An  
Coimisiún  
Pleanála

**Direction**  
**ABP-320327-24**

The submissions on this file and the Inspector's report were considered at a meeting held on 19/11/2025.

at Kippure Lodge and Holiday Village, Kippure Estate, Manor Kilbride, Blessington, County Wicklow is or is not development or is or is not exempted development:

CLIENT	Tondo Ltd.		
JOB TITLE	Development at Kippure Estate		
LOCATION	Manor Kilbride, Blessington, Co. Wicklow		
STATUS	Pre-Planning		CHECKED AB
DRAWN	NF		APPROVED AB
DRAWING No.	PL-0708-01-KE	DRAWING TITLE	REVISION
		Structure 07 & 08

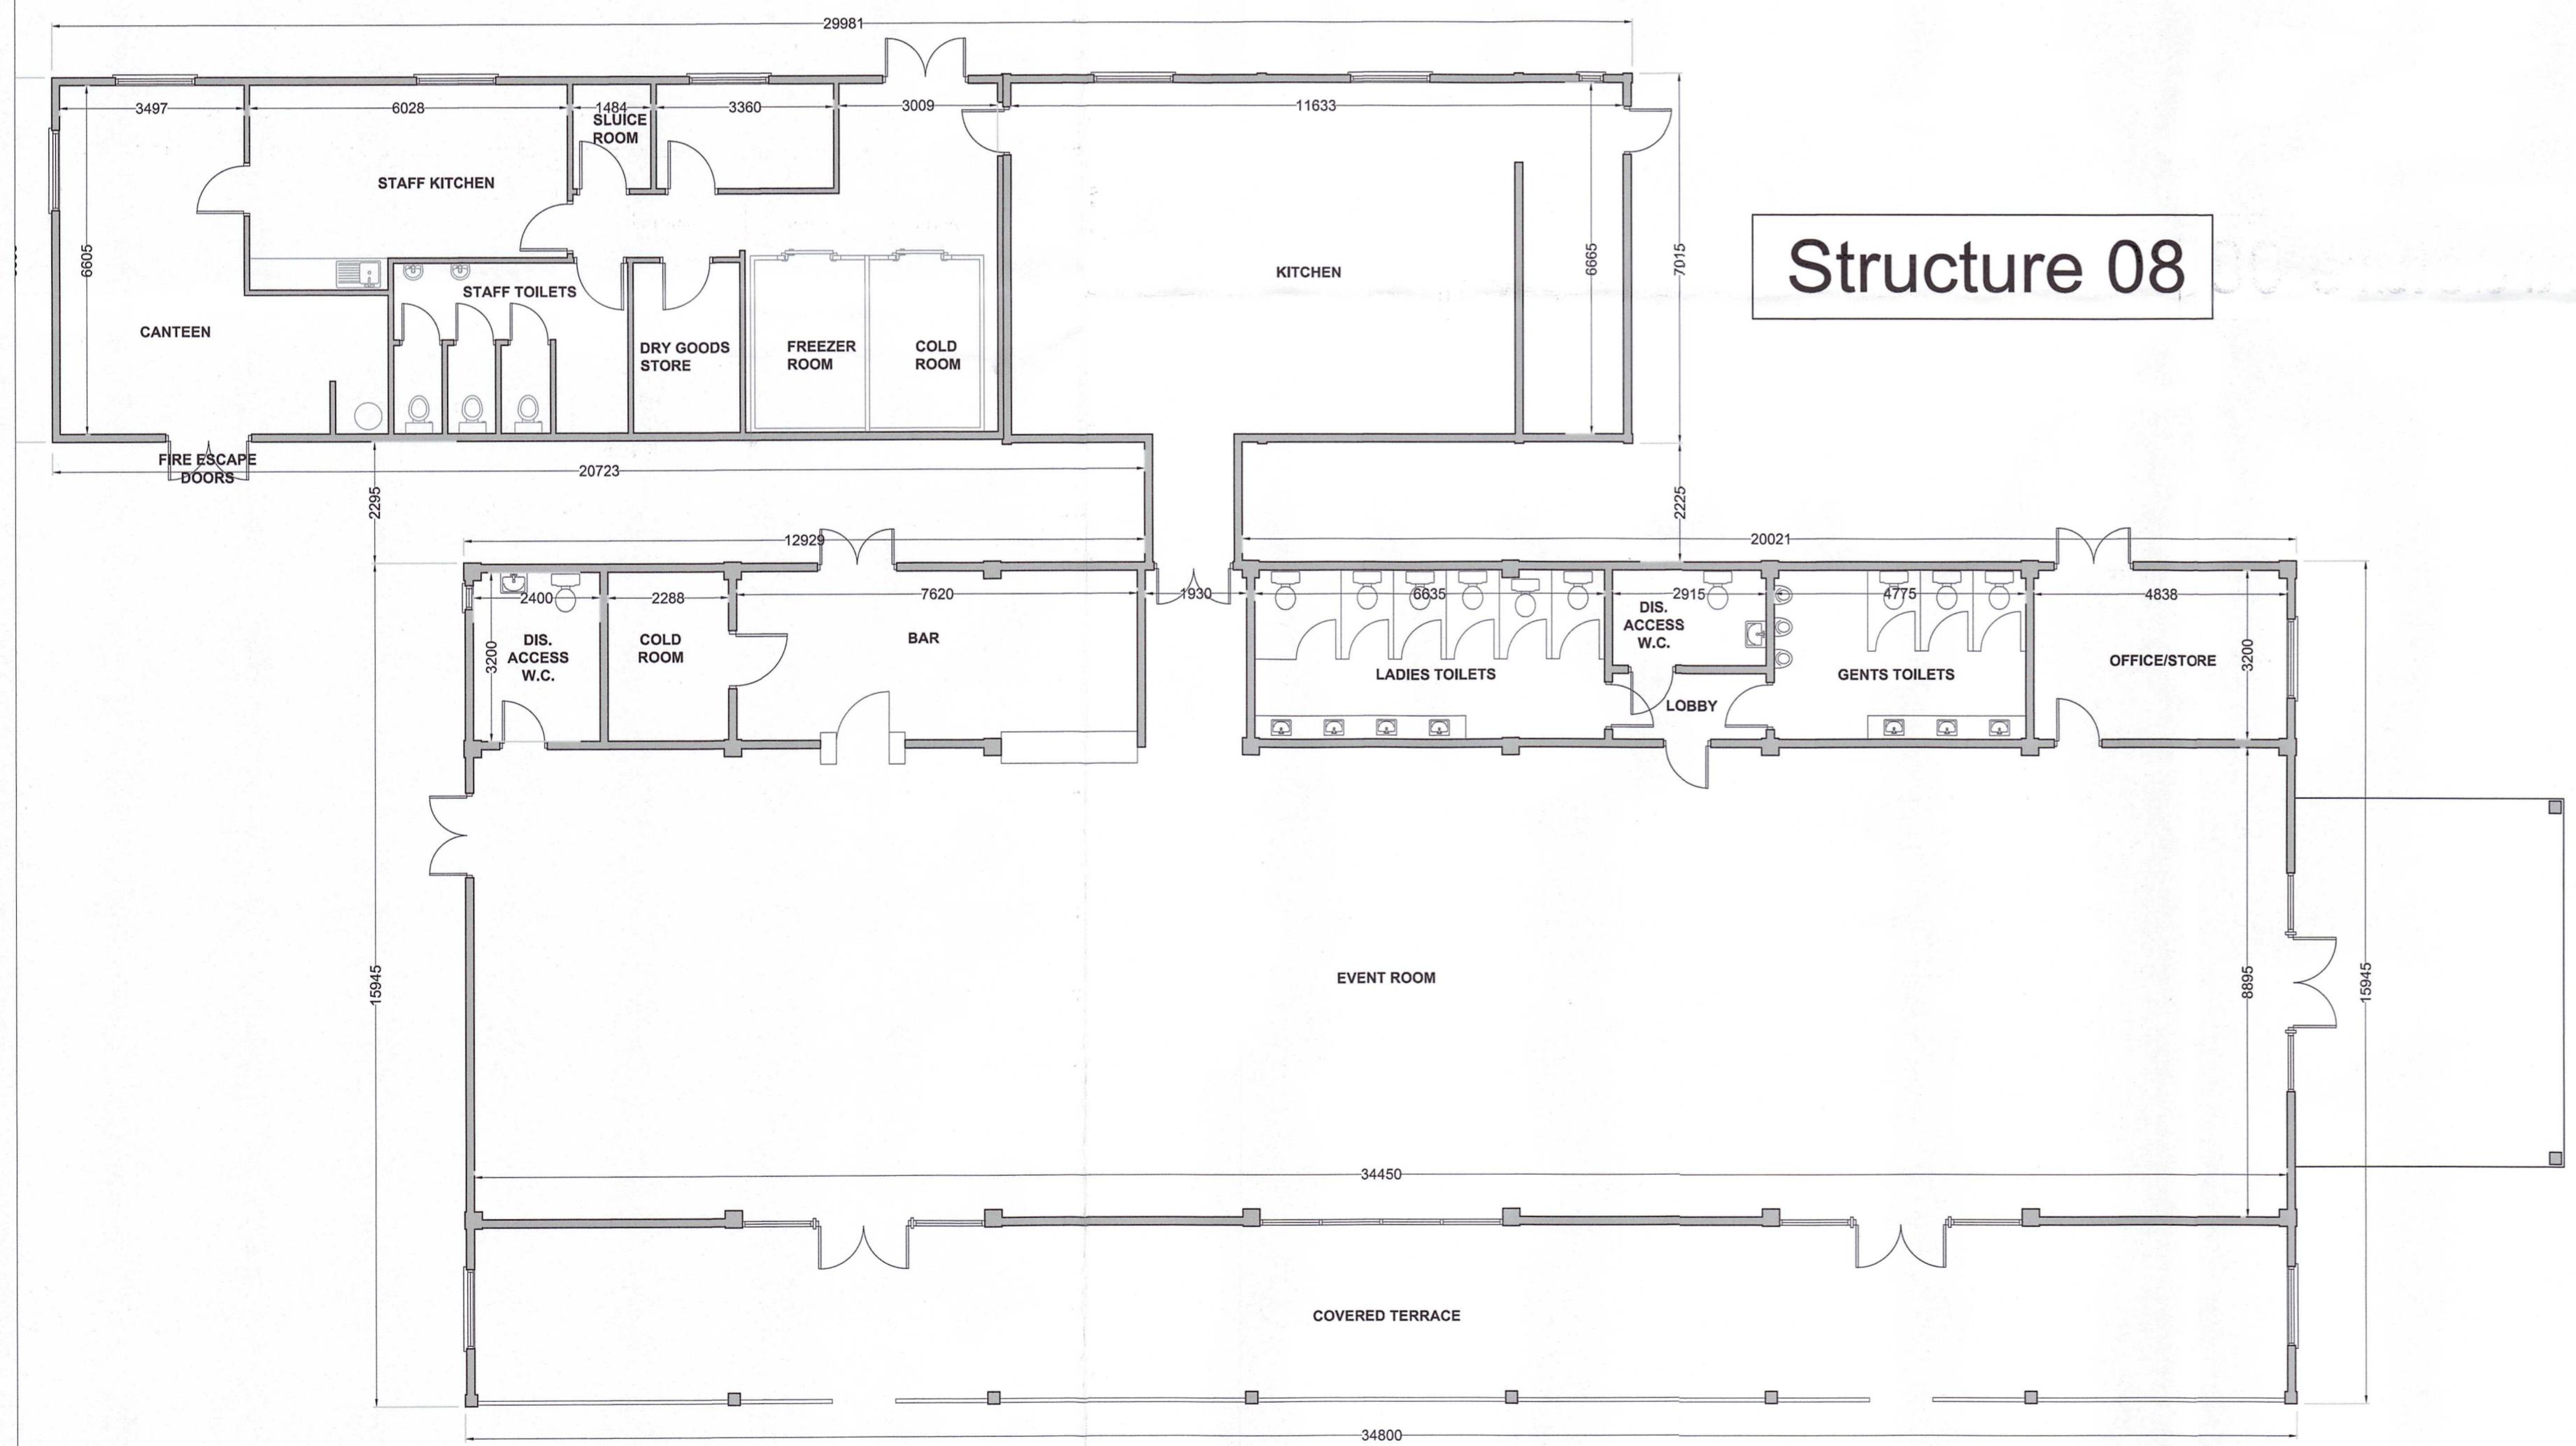
- (g) Structure Number 7 and Structure Number 8: The construction of the pavilion and kitchen buildings do not come within the scope of Section 4(1)(h) of the Planning and Development Act, 2000, as they are new structures. Therefore, these structures do not constitute exempted development.
